**BOTLEY WEST SOLAR FARM**  
**OXFORDSHIRE HOST AUTHORITIES**  
**Response to SoS Request for Additional Information**  
**09 June 2026**

Botley West Solar Farm (EN01014)

### **Purpose of this Submission**

Foundations Within Root Protection Area

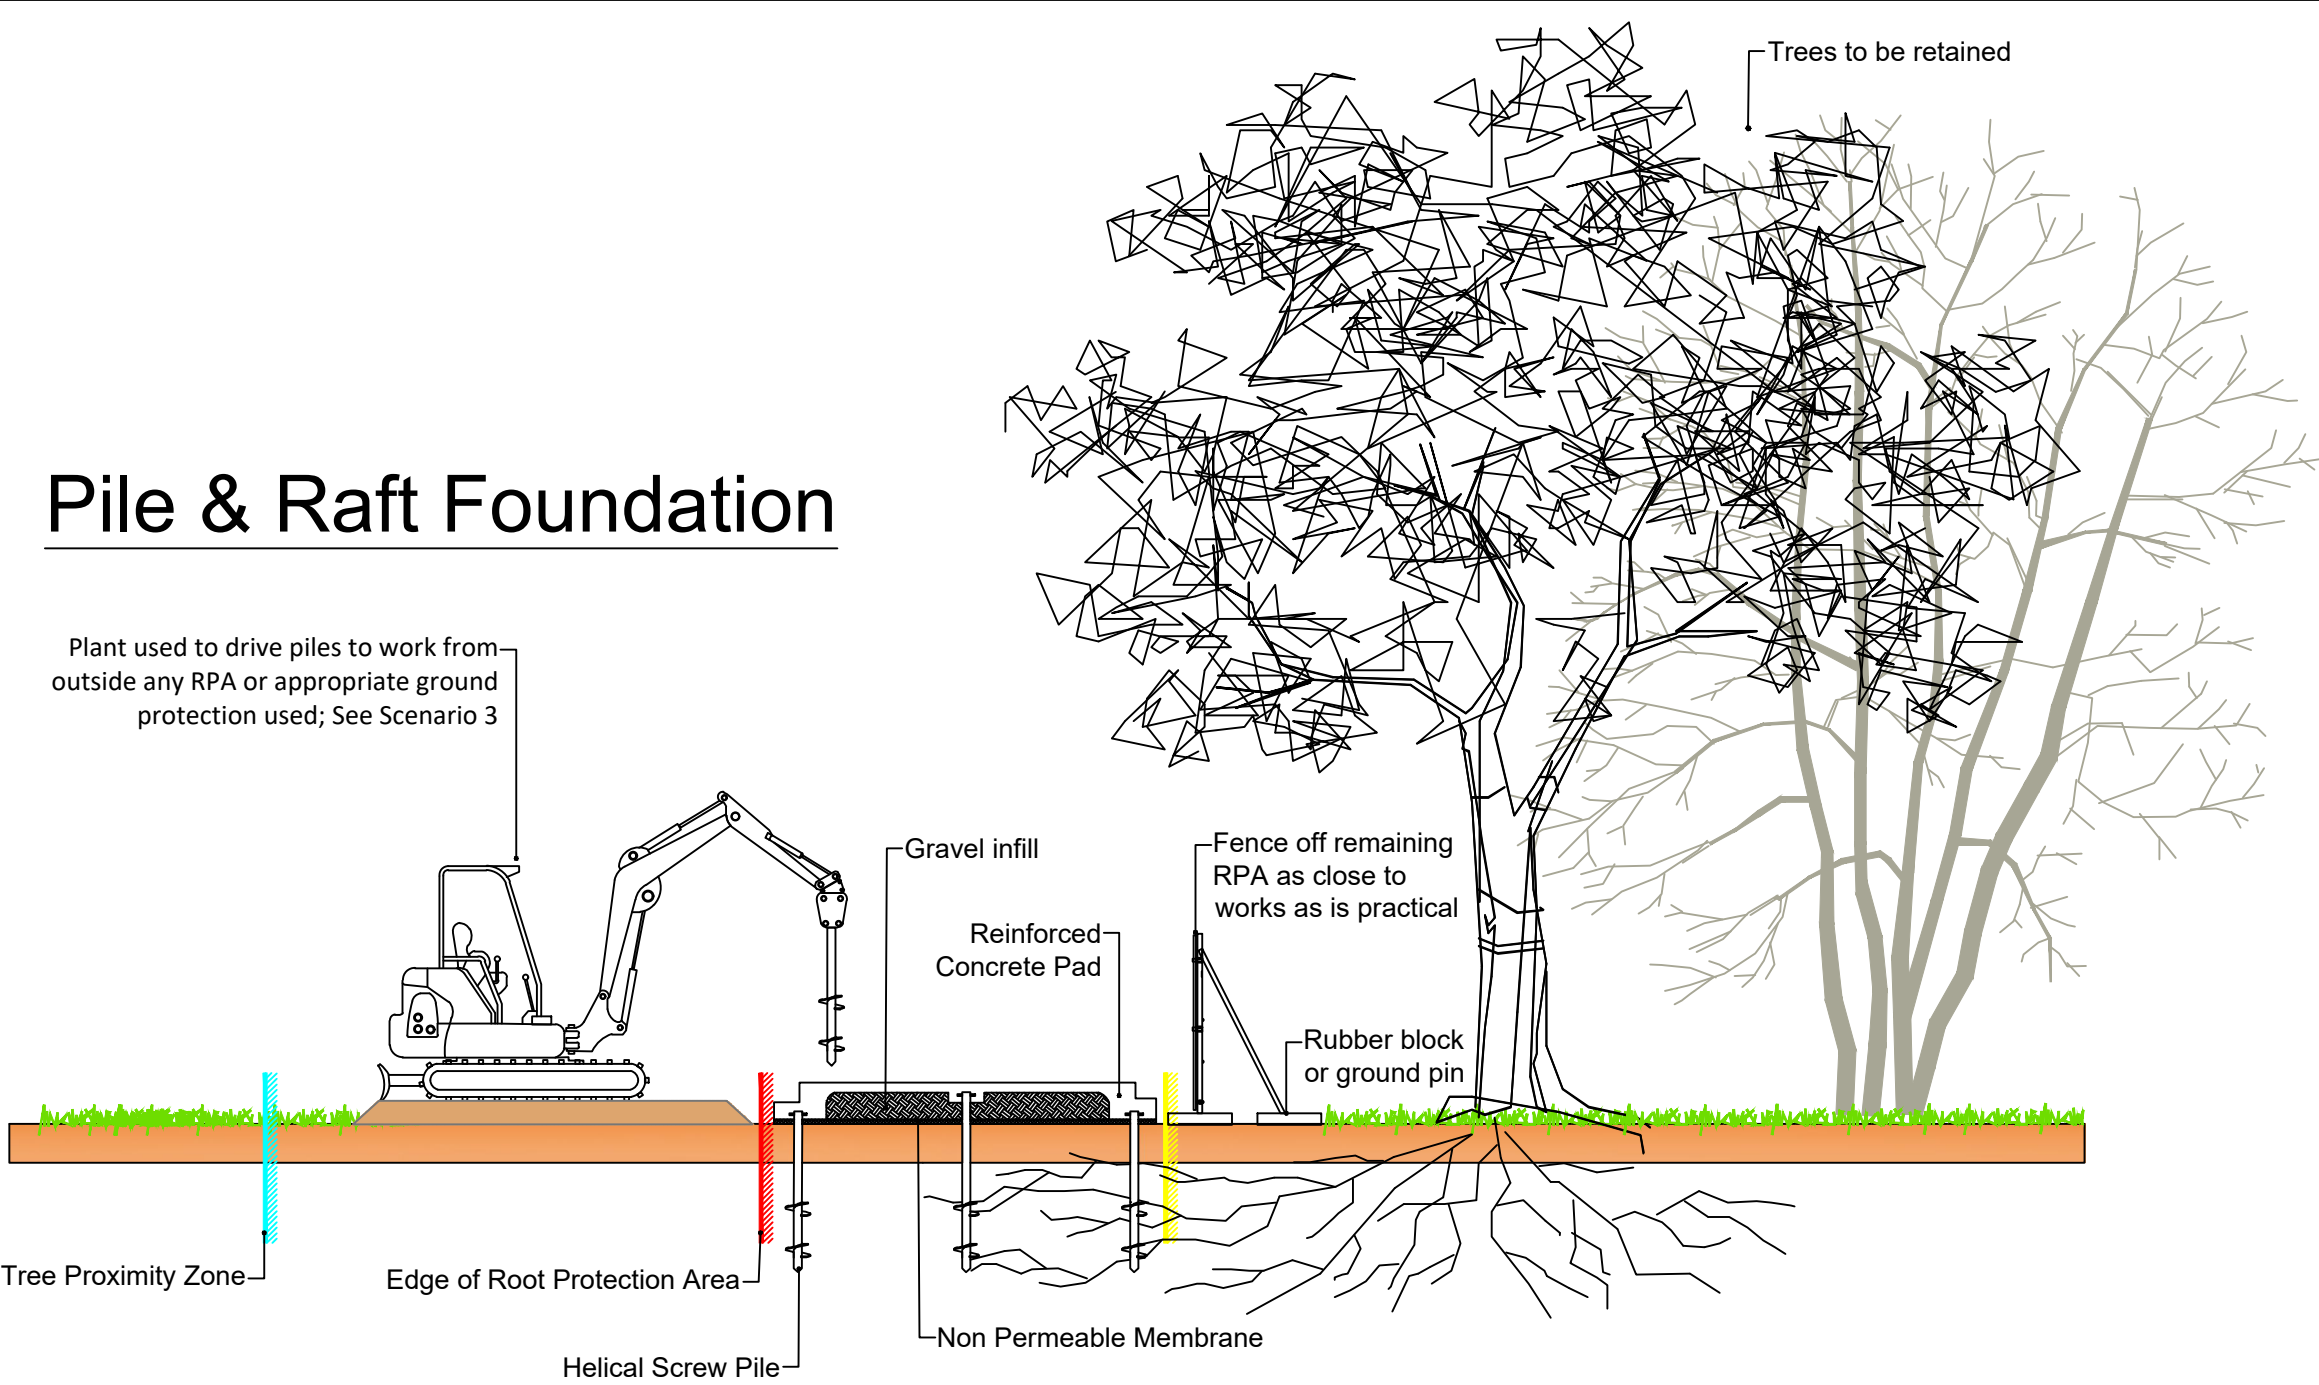
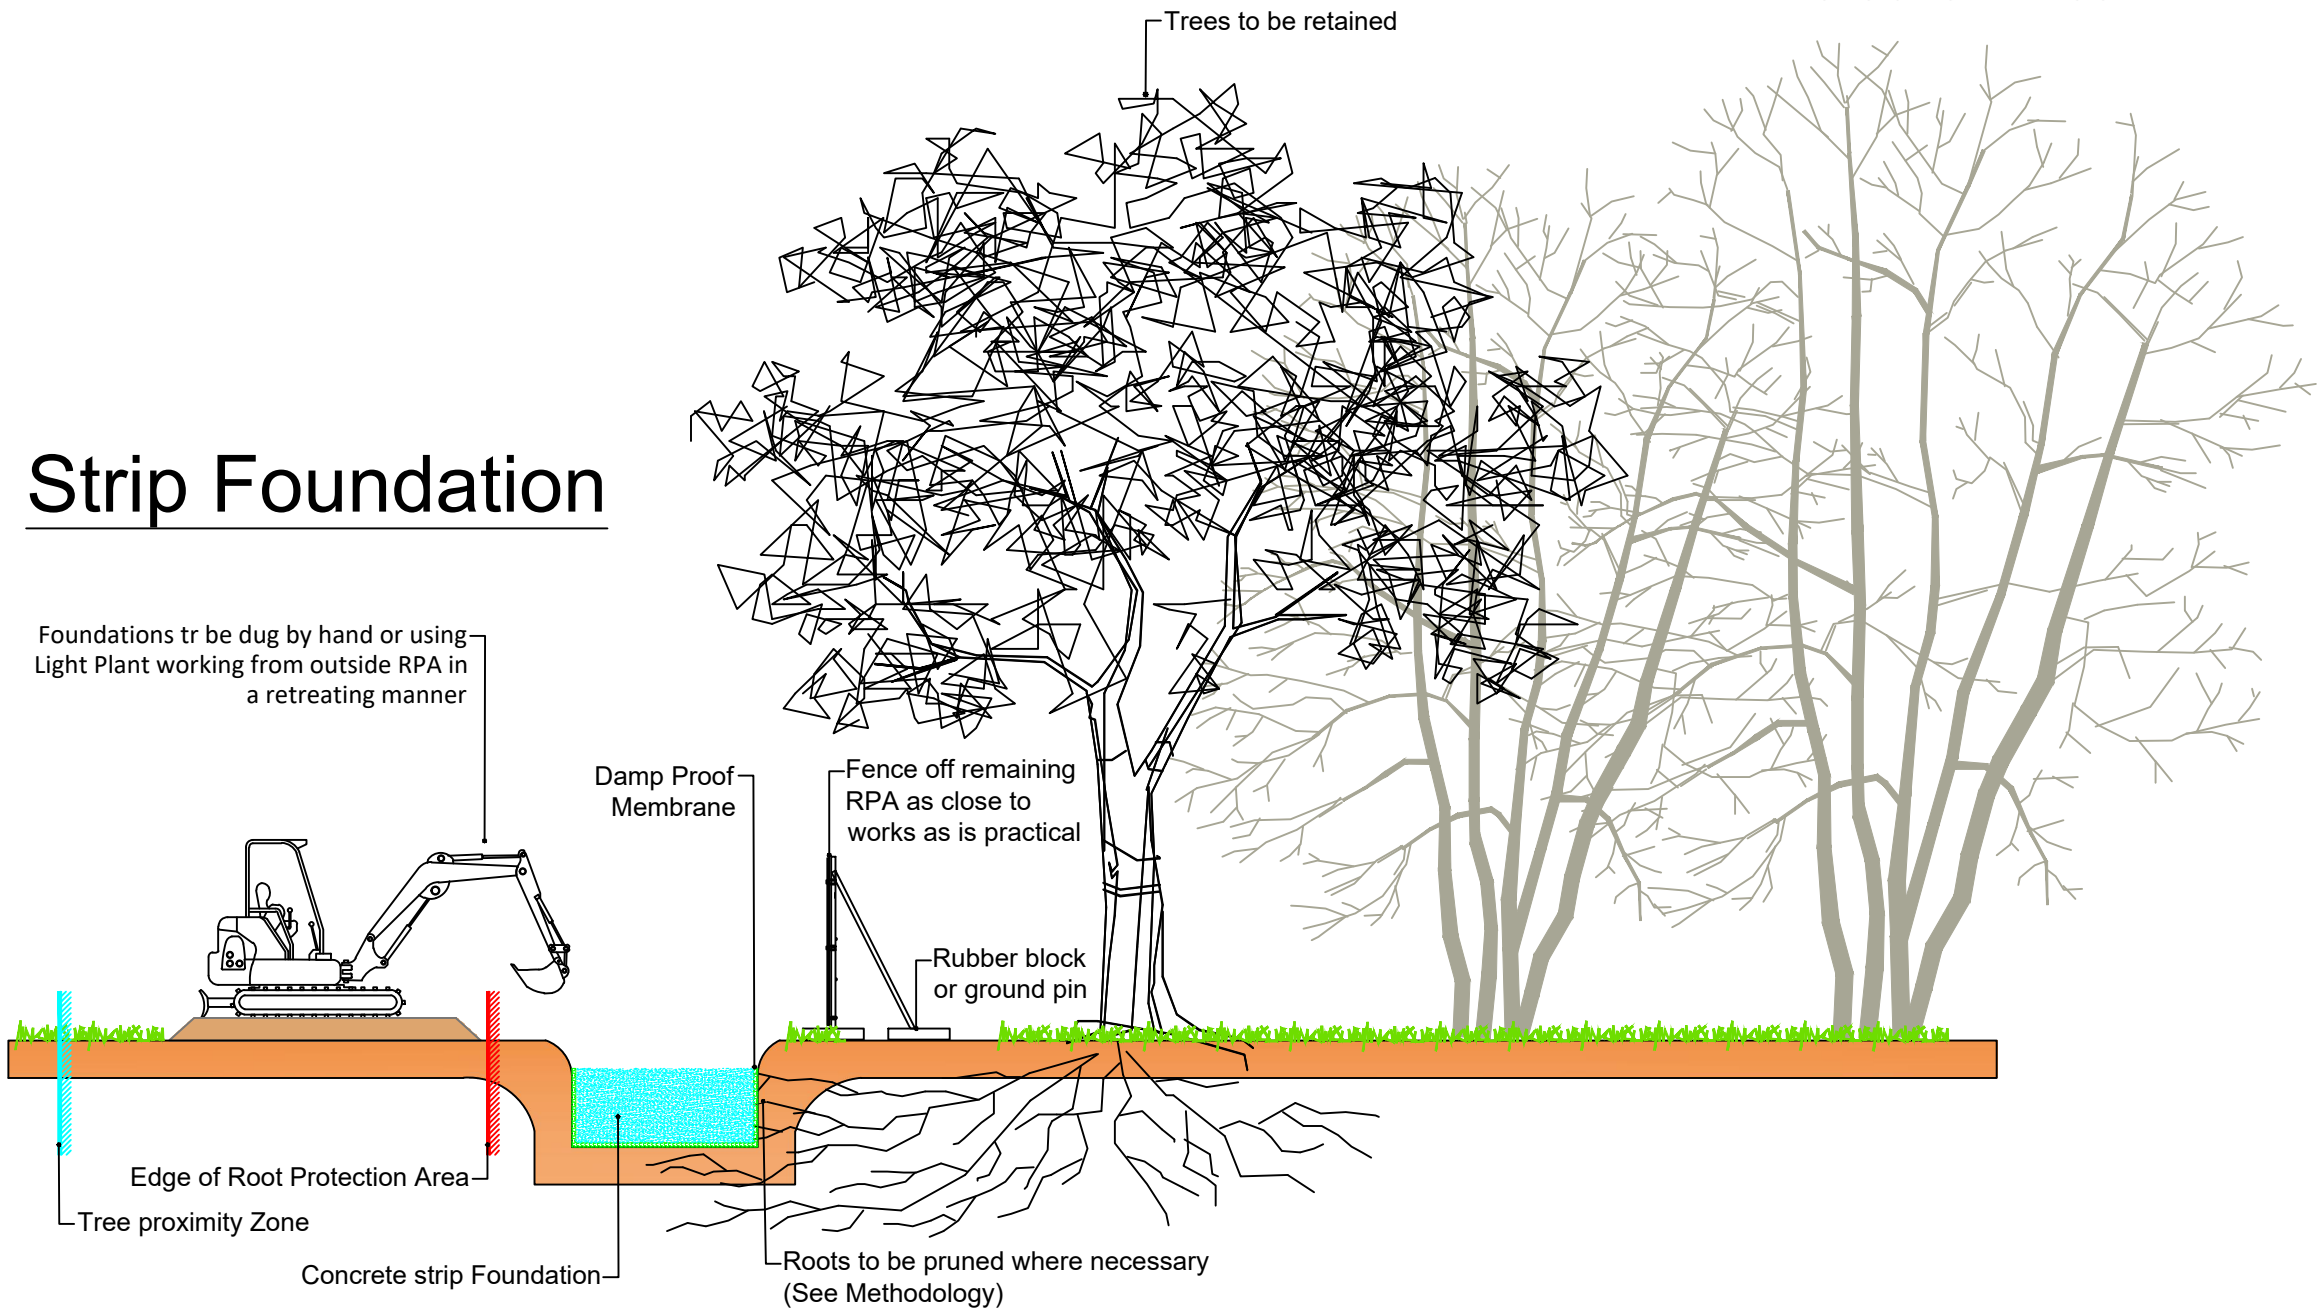
<p>tasked where appropriate. These will be used to reduce arboricultural impacts and help to inform detail arboricultural working methodologies where necessary.</p> <p>27. The OHA consider that reserving focused tree survey work until the detailed design stage means that the impacts of the proposed development on trees and woodlands have potentially been underestimated through the design stage and that there is potentially significant work required of the OHA Tree Officer or Arboricultural Consultant prior to the construction phase, to determine whether the correct scenarios have been applied in each situation, where veteran and ancient trees have been identified, or where they are yet to be identified.</p> <p>28. Once the Tree Protection Protocol Flowchart in Appendix C [REP6 -018] has been used to identify the correct Tree Protection Scenario, the methodology on the appropriate reference card in Appendix C should be used to set up tree protection before any other work is carried out.</p> <p>29. The OHA agree that the scenarios presented in the tree protection protocol provide a range of options for works within and in proximity to root protection areas, but would wish to be engaged in determining which scenario should be applied. It is not clear how or when this would be decided.</p> <p>30. In terms of the scenarios the applicant has presented for trenching in the Root Protection Areas (RPA), the OHA would require confirmation of which scenario is to be applied in each case. The OHA</p>

<p>have concerns about the use of the Strip Foundation scenario within root protection areas.</p> <p>31. Para 6.1 of the Tree Protection Protocol (Appendix C) [REP6-018] states that trenching within the RPA of retained trees shall only be carried out if absolutely necessary. Any proposed work that will require trenching within RPAs shall first be assessed to see if it can be diverted in order to protect trees. The OHA wish to understand how and when this will be decided.</p> <p>32. For HDD 11 the OHA have determined that the applicant is likely proposing Scenario 6, for works in relation to a Veteran Tree. A clearer representation as to whether trenching is proposed in the root protection area or the buffer area would be helpful, although we acknowledge and agree with the SoS that the Strategic Arboricultural Impact Assessment &amp; Method Statement should be updated to state that there will be no trenching in veteran tree Root Protection Areas. This would allay the concerns of the OHA as to whether the appropriate scenario would be implemented. The OHA consider that the mitigation hierarchy should be applied; any proposed works within the RPA of veteran trees and above is unacceptable and should be avoided.</p> <p>33. The Tree Protection Protocol Scenario 6 is not acceptable. Using machinery to excavate within RPAs is likely to lead to excessive and adverse arboricultural impacts, contrary to section 7.2.1 of BS 5837:2012 which states ‘To avoid</p>

Breaking Out Hardstanding Within RPA

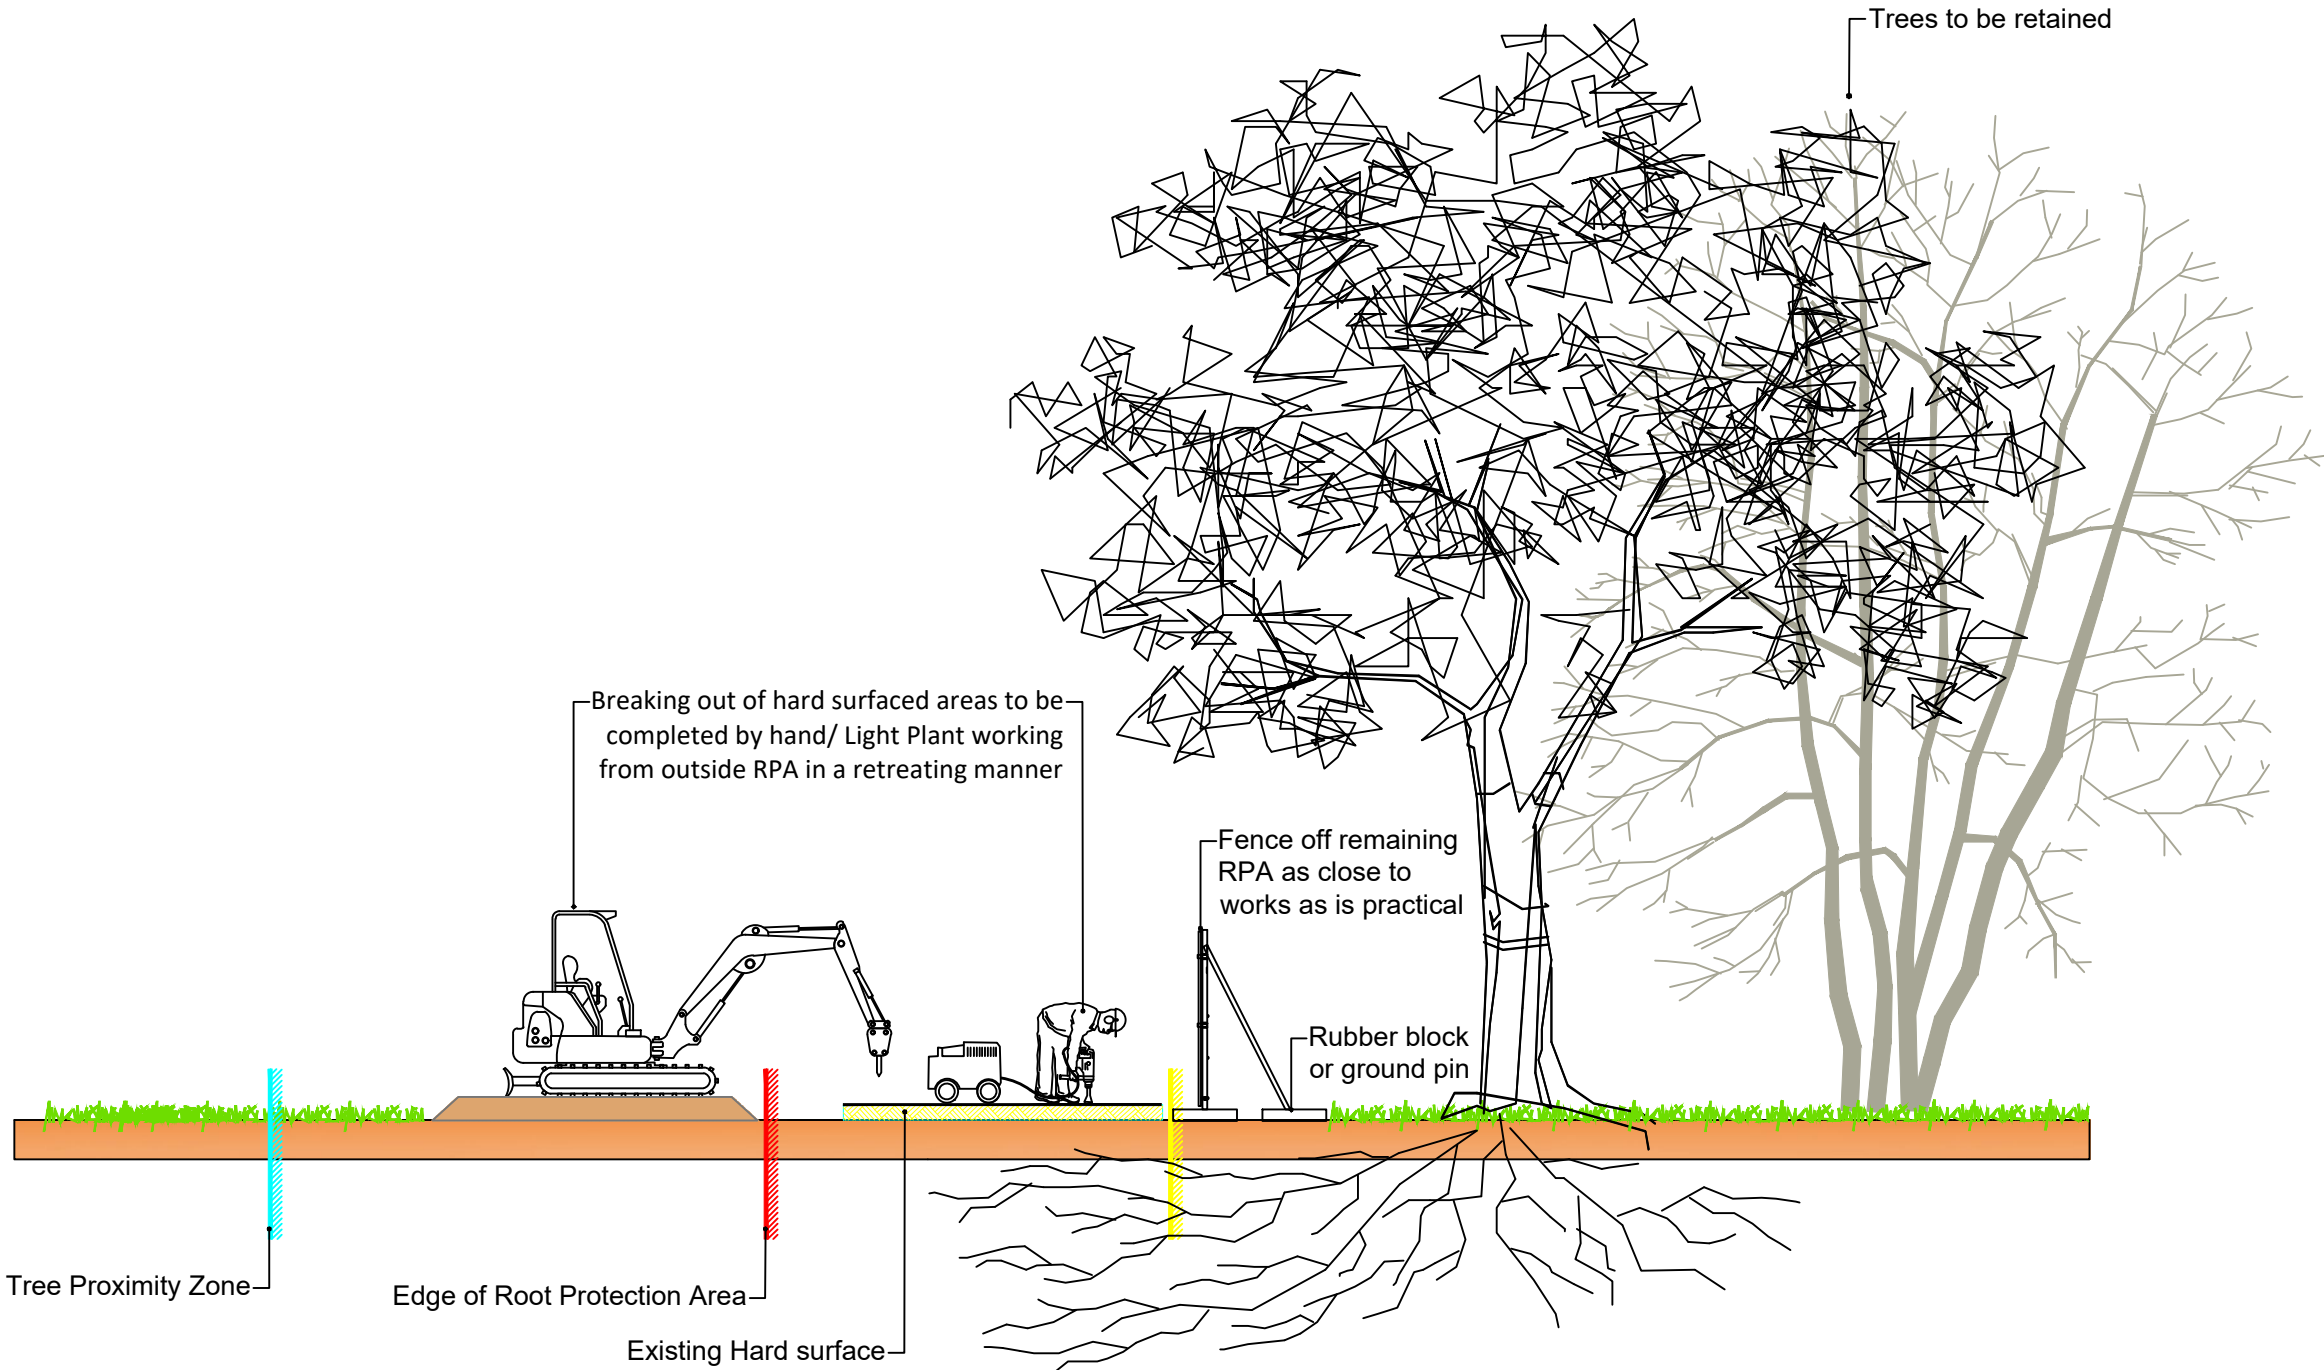
<p>damage to tree roots, existing ground levels should be retained within the RPA. Intrusion into soil (other than for piling) within the RPA is generally not acceptable, and topsoil within it should be retained in situ. However, limited manual excavation within the RPA might be acceptable, subject to justification. Such excavation should be undertaken carefully using hand-held tools and preferably by compressed air soil displacement’. NJUG Volume 4 also provides guidance for installing utilities within proximity to trees.</p> <p>34. The methodology is not clear as to how trenching will be decommissioned at the end of the project. Will it involve any soil improvement? The OHA require clarification as to how trenching will be rectified at the decommissioning stage.</p> <p>35. The OHA agree that clarification is required on how the potential impacts of HDD will be managed at Crossing Point 3 – The OHA assume that scenario 10 would be implemented as the cable route would follow the road or verge, but appears to cut directly through the RPA of several notable trees identified by the Ancient Tree Inventory.</p> <p>36. Scenario 10 appears to be the likely method to be implemented at HDD9, following the road or verge, but is directly cutting through what would be the RPA of tree T71. It would be useful to understand the specification of how deep the cables will go in this section, if it will go under or through the road. If breaking out of hard surfaced areas is to be</p>

<p>completed by hand or light plant working from outside the RPA in a retreating manner, it would be useful to know how and when this will be determined and what specific methods will be used.</p> <p>37. A clearer representation of works in relation to HDD5 would be useful as it is apparent that there are a number of trees that could be affected in this area including T40, T41 and T42. These may require additional buffering.</p> <p>38. The OHA have previously stated at LIR that we consider a greater buffer (50m) to ancient and veteran trees and ancient woodland to be necessary, in line with Woodland Trust Guidance.</p>
<p>51- Minerals</p>	<p><i>The Secretary of State notes the Applicant prepared a Mineral Resources Assessment (“MRA”) [APP-195] which estimated that 270 ha of the project area falls within Mineral Safeguarding Areas (“MSA”). Within the MRA the Applicant estimates a volume of 4,581,500m<sup>3</sup> of sand and gravel resource would be sterilised for the duration of the Proposed Development. In line with NPS EN-1 paragraph 5.11.19 the Secretary of State requests the Applicant to provide justification on</i></p>	<p>39. No further discussions have taken place with the OHA on this matter. In its capacity as Minerals and Waste Planning Authority, Oxfordshire County Council will review and comment on any further submission from the Applicant</p>
